Application No: AB/75/21/HH
Site Address: 54 Tarrant Street Arundel BN18 9DN
Description of works: Alterations to fenestration and installation of 4 x new rooflights and waterproofing system to basement and outbuilding. This application may affect the character and appearance of the Arundel Conservation Area and the setting of a listed building.

Thank you for your internet representation made on 6th July 2021 which has been recorded as an objection with the comments as follows:

Objection

PROPOSED DETAIL FOR
 WINDOWS W6, W7, W8 + W9
 WHICH WILL BE DOUBLE GLAZED

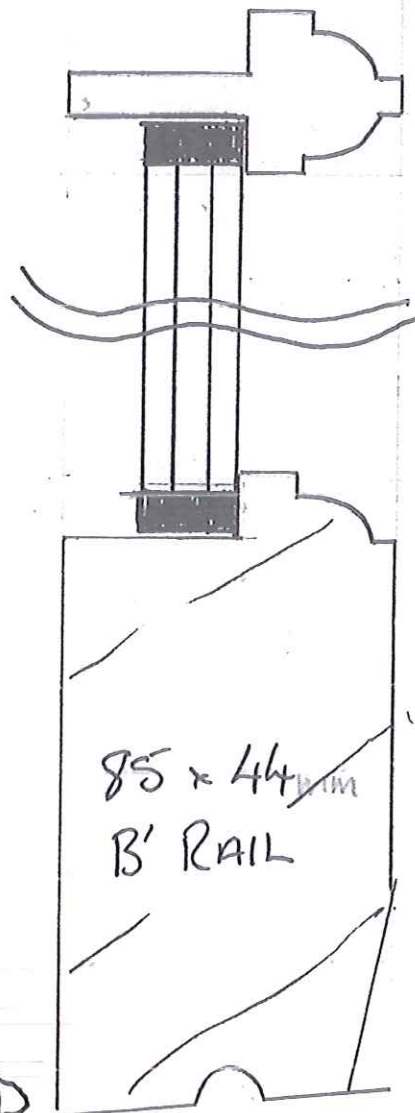
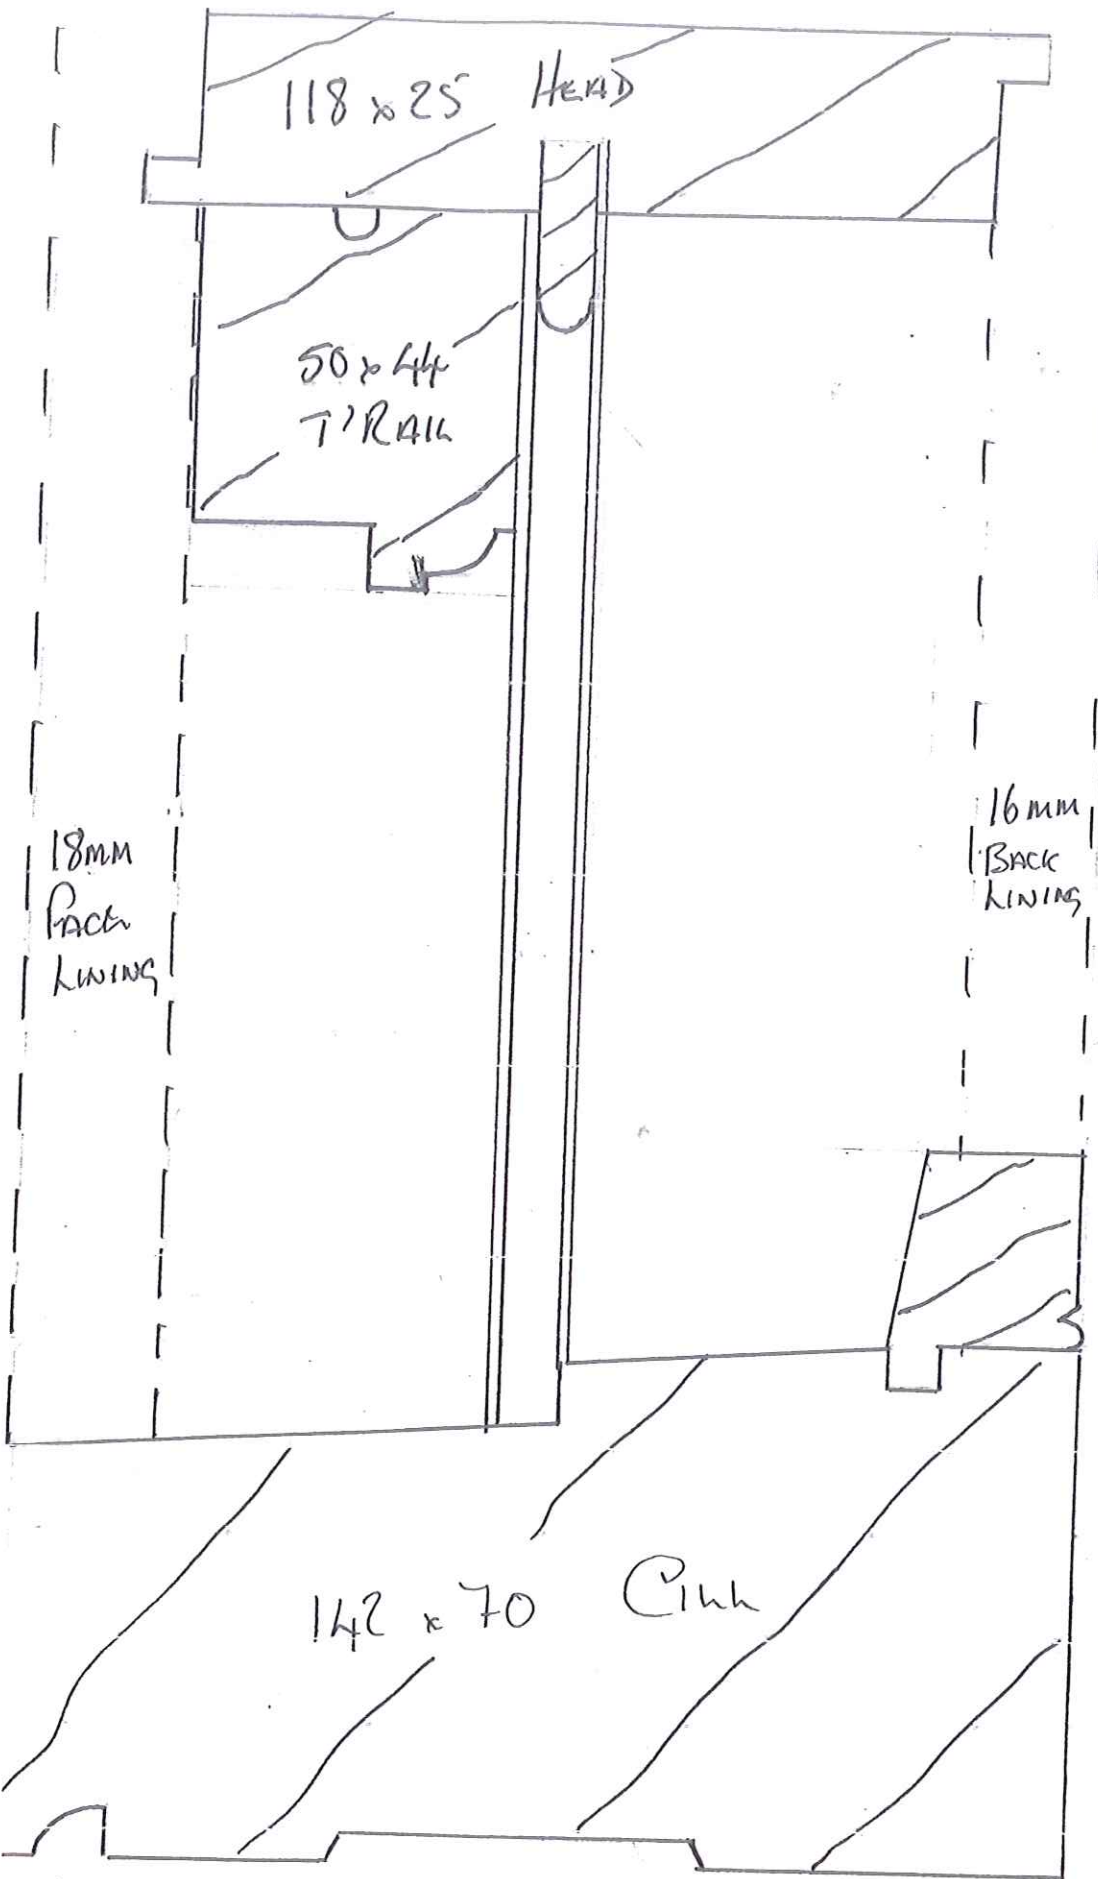
The Panel are concerned at the reference in the Design and Access Statement to double glazing for high level windows on the rear elevation of the building. There is a detailed section of the proposed new double glazed windows which shows the use of slimline units with glazing bars 2mm thicker than the existing ones. Given the location of the windows on the rear elevation the Panel consider that in this respect there will be no adverse impact on the appearance of the conservation area.

However, there is no detailed condition report to indicate the age of these windows or that they are beyond reasonable repair. Historic England's advice is quite clear that repair is the preferred option before total replacement since the latter can involve the loss of significant historic fabric. This issue is also relevant in respect of the other windows proposed to be replaced.

In the absence of information to support the loss of the existing windows then the Panel consider that the grant of LBC would set a precedent for similar inappropriate proposals in the conservation area and possibly in historic buildings and areas elsewhere in the District. It is considered that on this issue the proposals will conflict with the relevant paragraphs of the NPPF and policies contained in the ADLP relating to the protection
